<b>Application Ref:</b>	3/2021/0124	 <b>Ribble Valley Borough Council</b> <hr/> <a href="http://www.ribblevalley.gov.uk">www.ribblevalley.gov.uk</a>	
<b>Date Inspected:</b>	11/03/2021		
<b>Officer:</b>	LE		
<b>DELEGATED ITEM FILE REPORT:</b>		<b>Decision</b>	<b>APPROVE</b>

<b>Development Description:</b>	Proposed raising of the existing roof and conversion of the existing loft to facilitate first floor accommodation and associated alterations and refurbishment works.
<b>Site Address/Location:</b>	Sunridge York Lane Langho BB6 8DW

6174-02

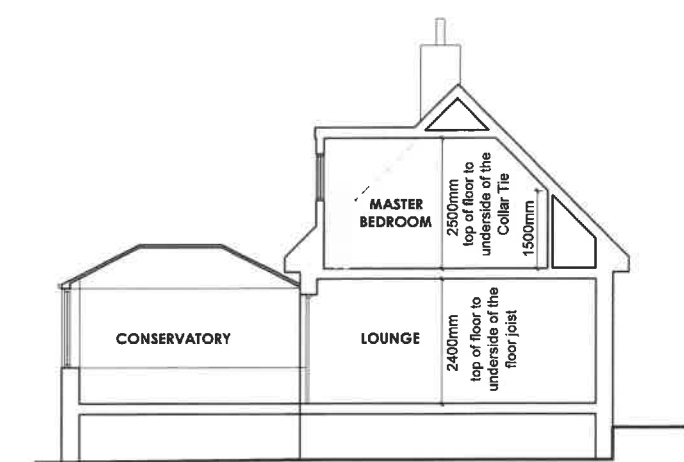
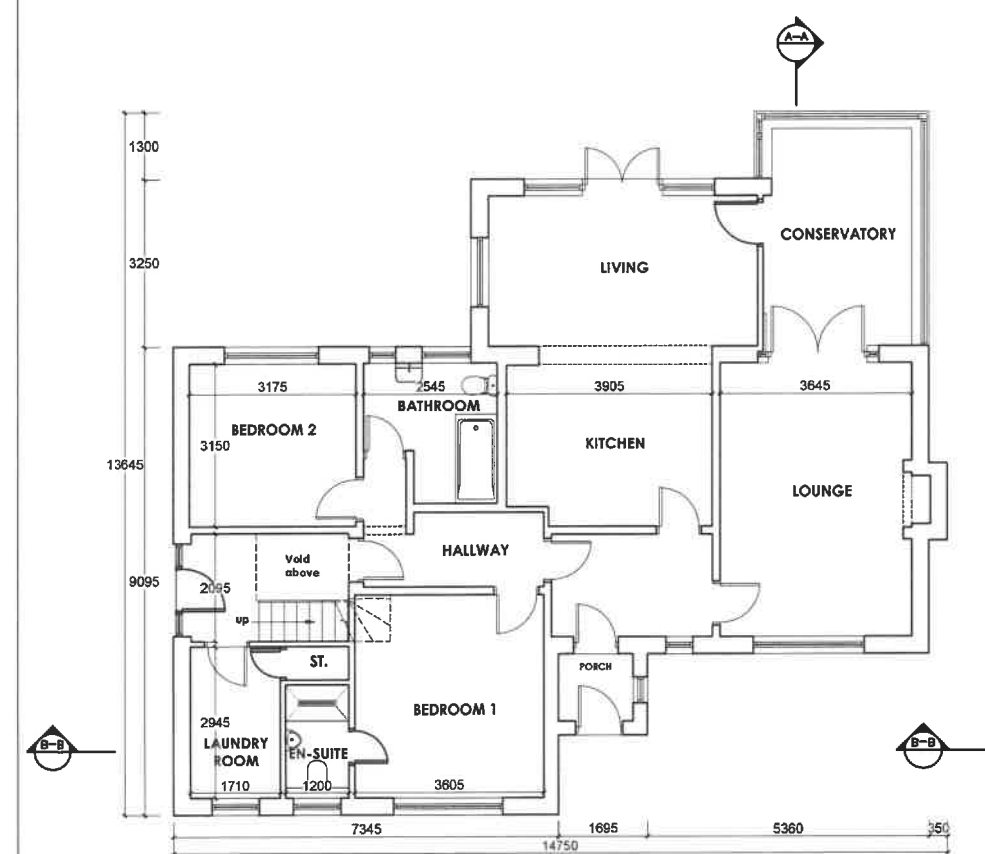
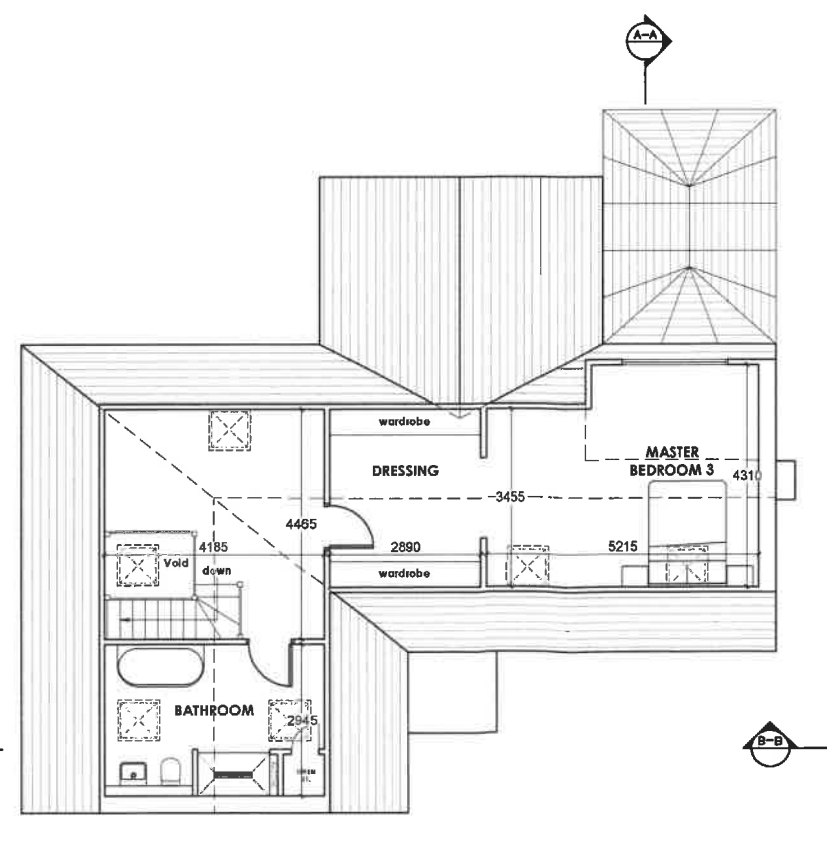
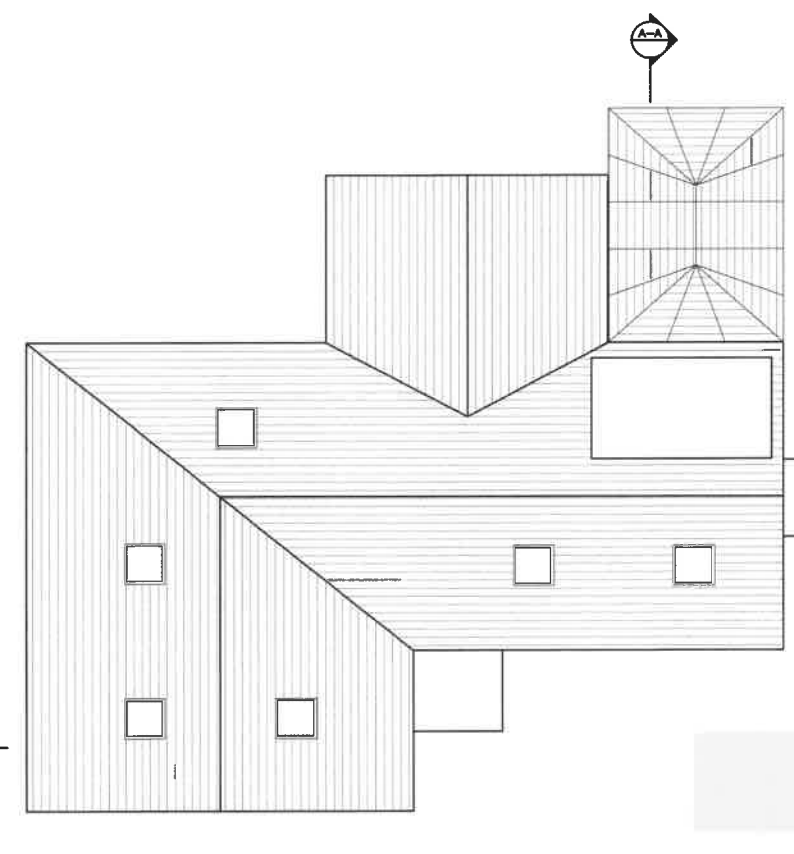
The alterations to the roof will result in an increase of the ridge height by 440mm, the hipped roof facing forwards will be removed and replaced by a pitched roof with forward facing gable to increase useable floor area within the roof. A dormer window serving the master bedroom is proposed to the rear.

A neighbouring property has raised concerns with regard to the introduction of a new habitable room window at first floor level which would overlook their garden. Whilst this arrangement would not be unusual in a residential street it is accepted that this is a concern given that they currently enjoy privacy on from this side being adjacent to a bungalow.

The dormer is set back within the roof and has a centrally positioned window with solid walls either side but it is located quite close to the edge of the property. The primary views will be directly to the rear but oblique sideways views into adjacent gardens are likely to be possible if the occupants are stood in the window looking out. The submitted statement explains the applicants wish to take advantage of the views beyond the rear boundary of the property.

It is considered that whilst there may be some perceived loss of privacy as mentioned above it is not direct overlooking nor is it unusual in a residential street to have this arrangement and on balance the impact on residential amenity is not severe enough to warrant a refusal.
